## PLANNING CONSULTATION RESPONSE

<b>Application No</b>	2025/0920
<b>Proposal</b>	Demolition of existing side single storey extension and garage; erection of two storey side; rear single storey extensions; front entrance porch and detached double garage with alterations to driveway and parking arrangements.
<b>Address</b>	St Johns Close, 379 Carlton Road, Carlton, Barnsley, S71 3JB.
<b>Date of Consultation Reply</b>	16/12/2025
<b>Consultee</b>	Edward Jowett (Tree Officer)

**Appendix 6:**  
**Tree Impacts Plan**  
 379 Carlton Road, Carlton, Barnsley  
 Ref: AWA6984

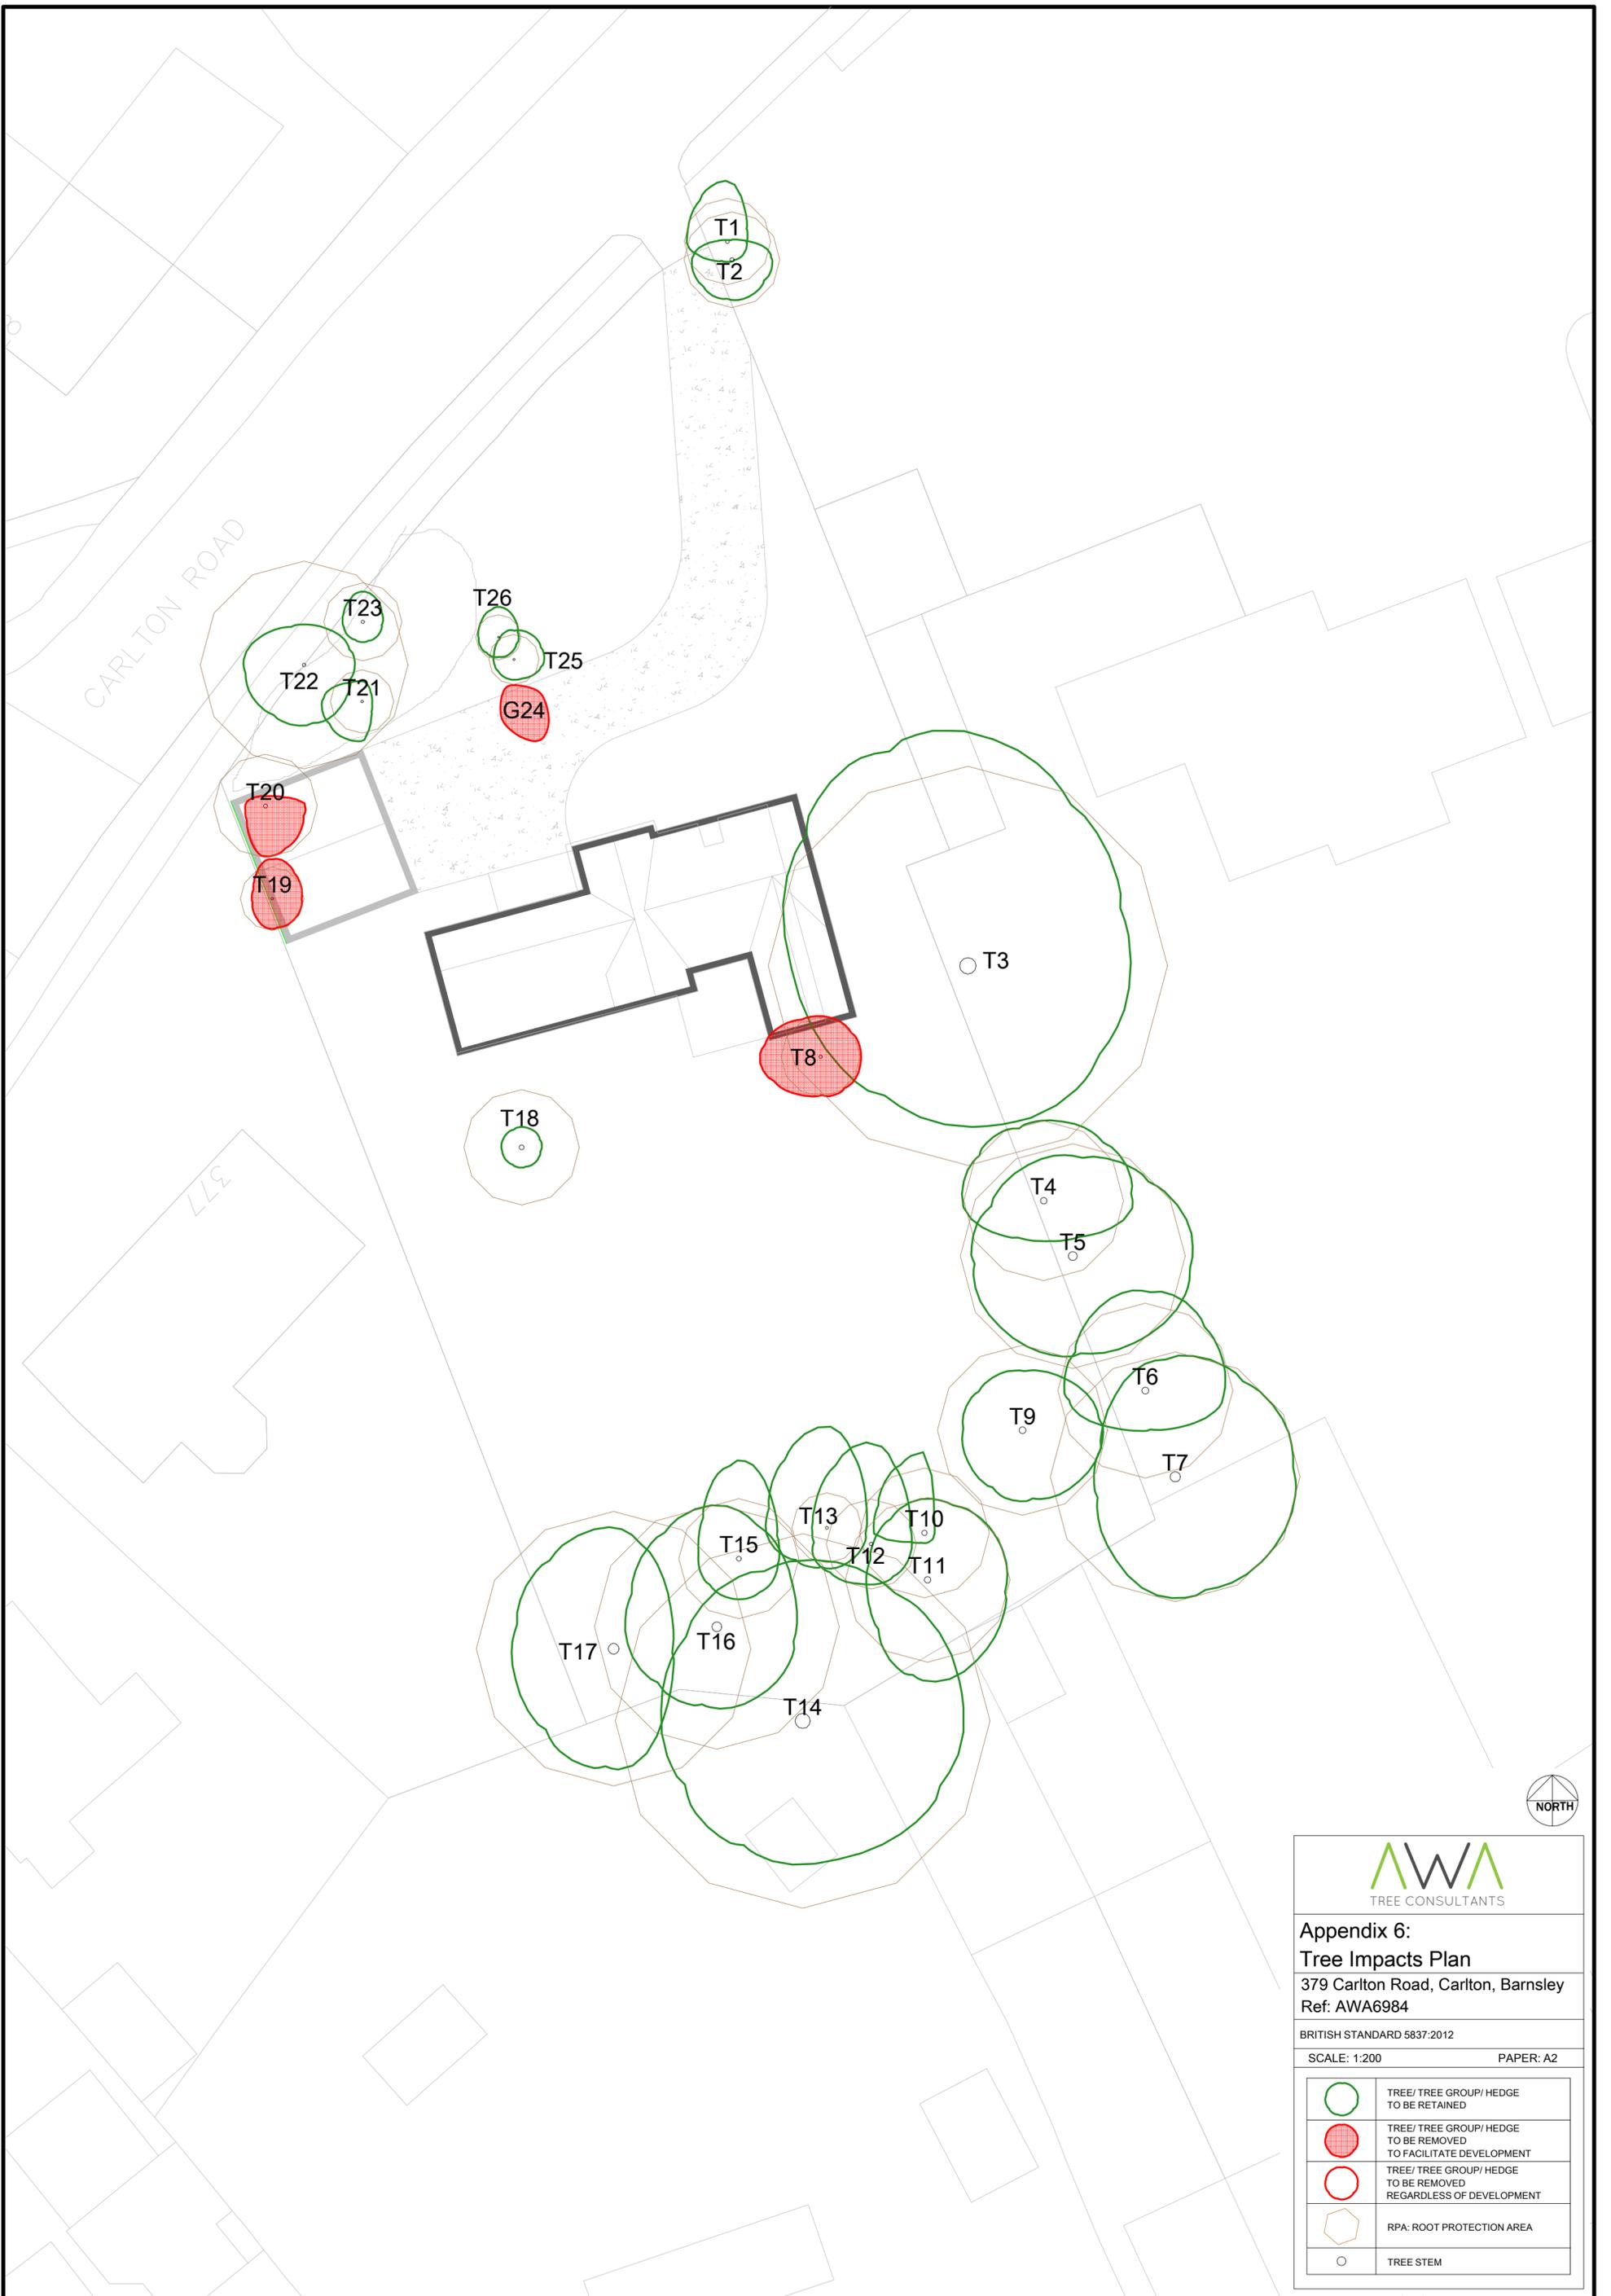
I have no objections to the proposal in principle as only relatively small easily replaced trees are to be removed. There are works in close proximity to trees such as the new garage and the access to it but these can be dealt with as part of an arboricultural method statement.

I do note that the off site protected tree T3 overhangs the proposed new two storey extension as it already overhangs the existing dwelling and buildings in that location. The works however will increase the height of the house under the canopy of the tree from one storey to two and as such it is not clear if the tree will be directly implicated and require works to facilitate the increase in height or how much clearance from the tree there will be. I would therefore ask that clarification regarding this be provided for the avoidance of any doubt before I make my final comments.
